REQUEST FOR INFORMATION ADDISON AIRPORT TUNNEL - JOB #9080.01 170

FINAL RECORD DRAWING Date: 12/25/99

NORTH TEXAS TOLLWAY AUTHORITY ADDISON AIRPORT TUNNEL

RFI# 156 - 170

No.	REVISION	BY	DATE
TEXAS TURNPIKE AUTHORITY ADDISON AIRPORT TUNNEL			
TUNNEL VENTILATION PLANS			
HDR HDR Engineering, Inc.			SECTION XIII
DRAWN: WTD	DATE: 12/05/96	DESIGNED: M.L.A.	DATE: 08/28/96
CHECKED: KG	DATE: 08/28/96	SCALE: 1" = 50'	
CONTRACT No. DNT-260 SHEET. M139 OF 166

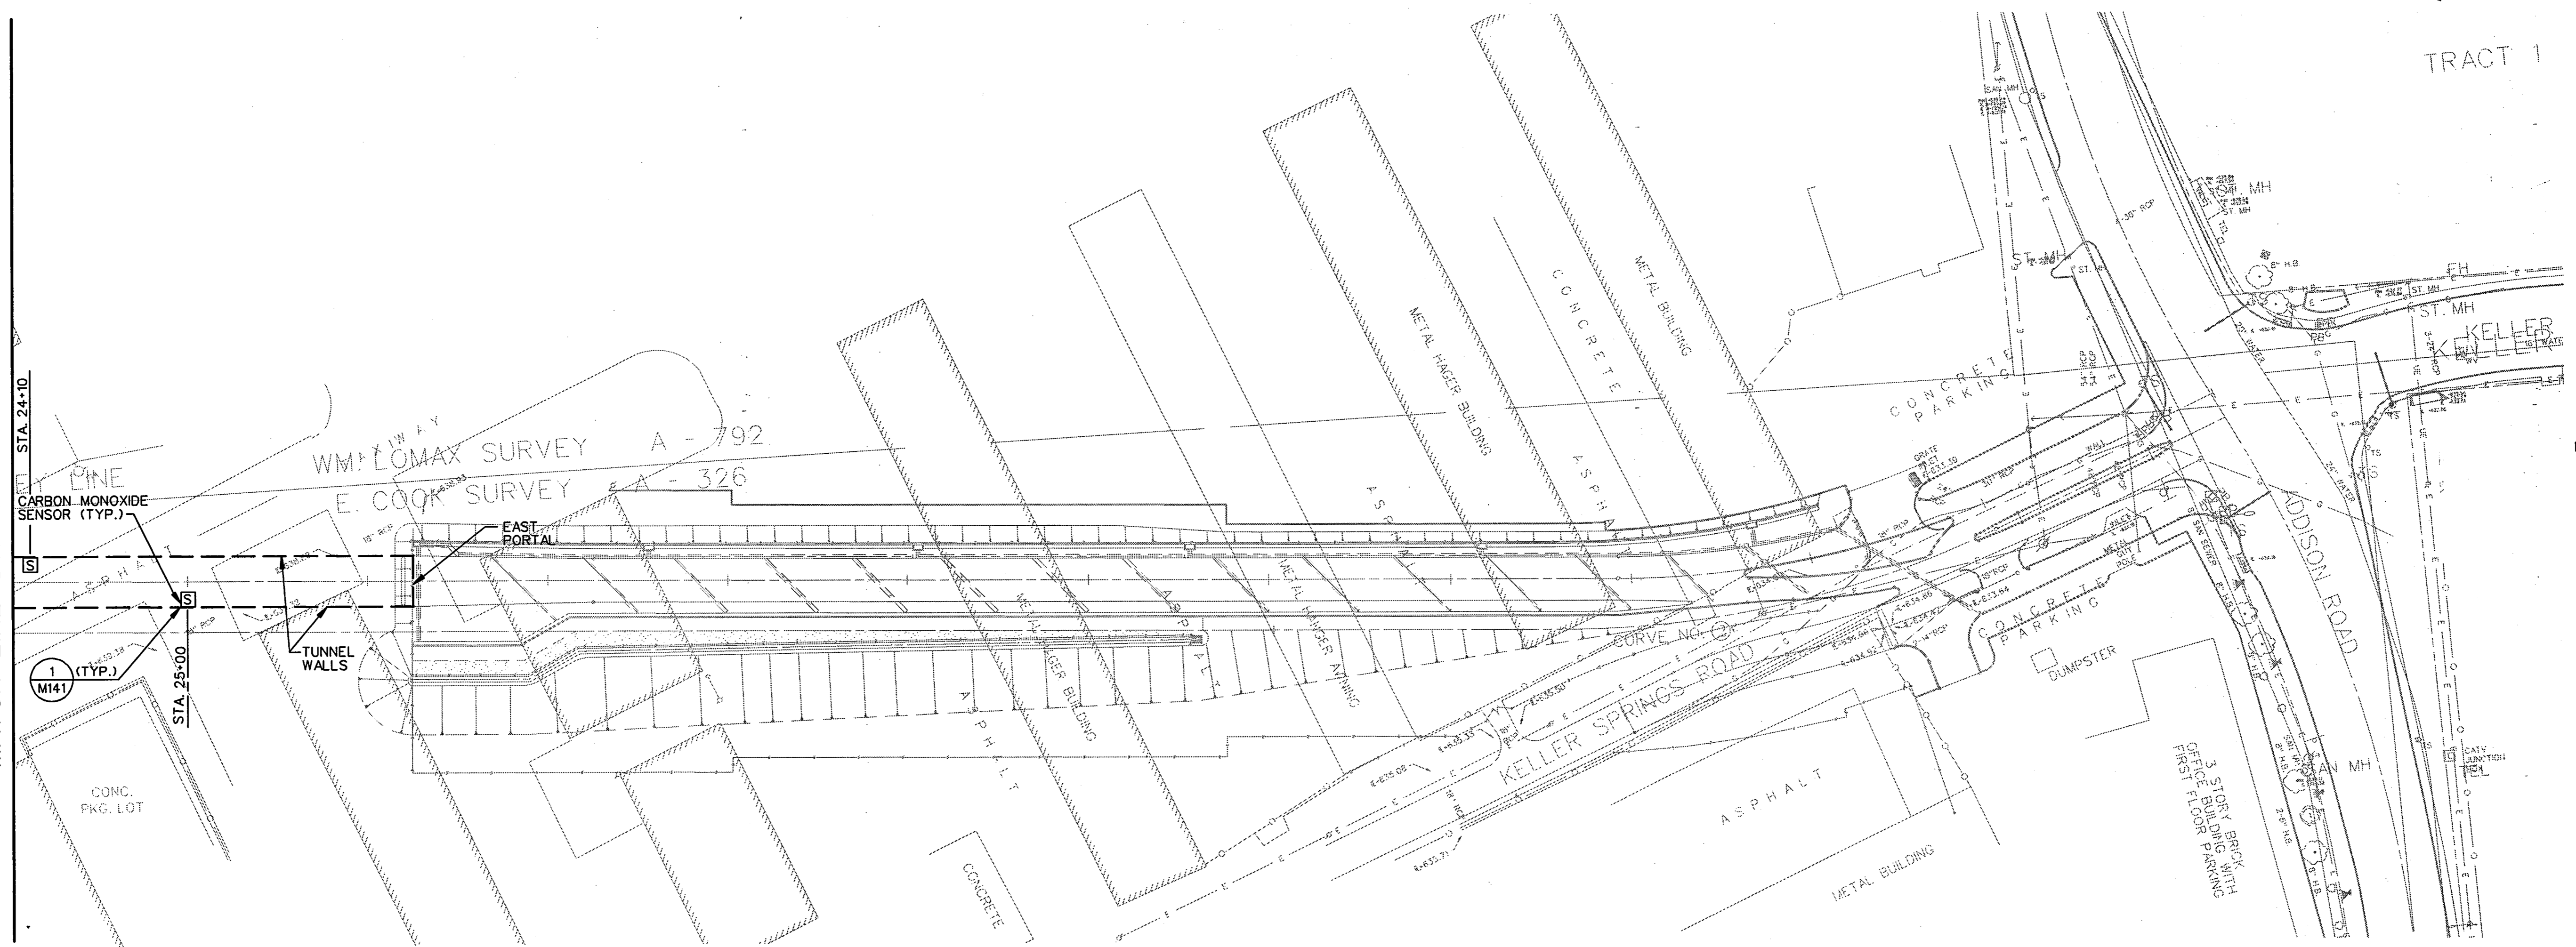
Problem: Our Submittal No. 7100-023 in reference to the above specification was returned to "finish as noted". One of the notes indicates to provide an air flow switch to detect air flow and air flow direction. Part 2.6.A of this section indicates to "Finish each fan assembly with an air flow switch that is capable of detecting airflow in either direction of motor operation." Our supplier can not locate a switch which detects air flow and air flow direction. Please provide us a manufacturer's name for this type of switch.
